City of Portland, Maine - Building or Use Permit Application
 389 Congress Street, 04101 Tel: (207) 874-8703, Fax: (207) 874-8716

Permit No: 09-0523	Issue Date:	CBL: 436 A005001
------------------------------	--------------------	----------------------------

Location of Construction: 12 YALE ST	Owner Name: MJ DEVELOPMENT COMPANY LL	Owner Address: 31 OLD CAMPUS DR	Phone: 207-797-4380
Business Name:	Contractor Name: MJ Development	Contractor Address: 31 Old Campus Rd Portland	Phone: 2077761762
Lessee/Buyer's Name	Phone:	Permit Type: Single Family	Zone:

Past Use: Vacant Land	Proposed Use: Single Family Home - New Single Family Home -24x36 Colonial with 22x24 Attached Garage. Two Stories, 3 Bedroom, One 1/2 Bath	Permit Fee: \$1,295.00	Cost of Work: \$120,000.00	CEO District: 4
Proposed Project Description: New Single Family Home -24x36 Colonial with 22x24 Attached Garage. Two Stories, 3 Bedroom, One 1/2 Bath		FIRE DEPT: <input type="checkbox"/> Approved <input type="checkbox"/> Denied	INSPECTION: Use Group: Type	
		Signature: _____		Signature: _____
PEDESTRIAN ACTIVITIES DISTRICT (P.A.D.)				
Action <input type="checkbox"/> Approved <input type="checkbox"/> Approved w/Condition <inp

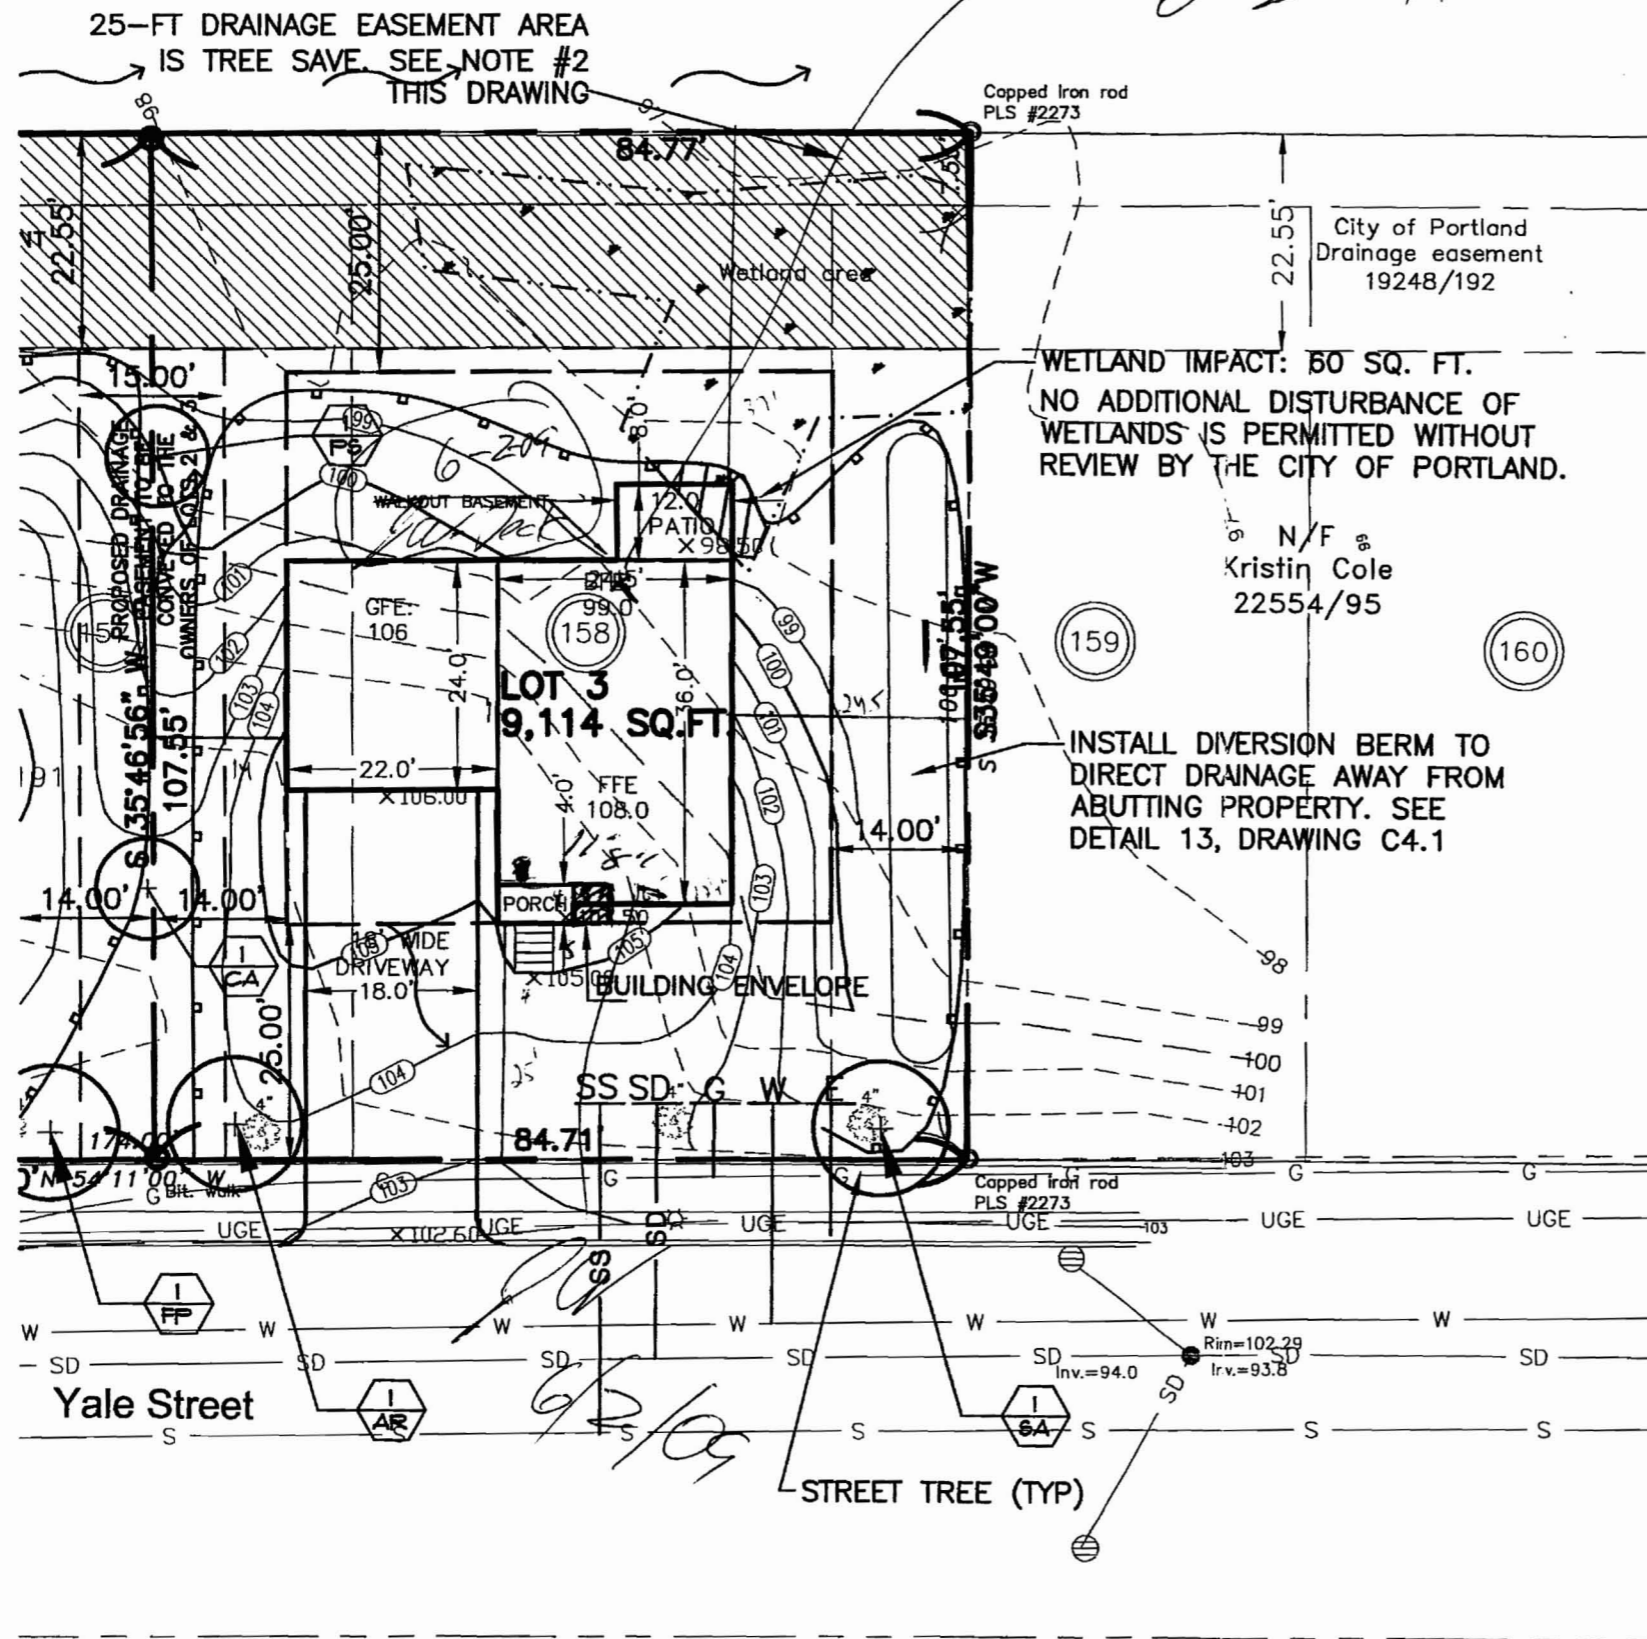
Comments:
6/2/2009-amachado: Dimensions on the building plans don't match the dimensions on the siteplan. Spoke to Jim Wescott. He submitted revised plans.
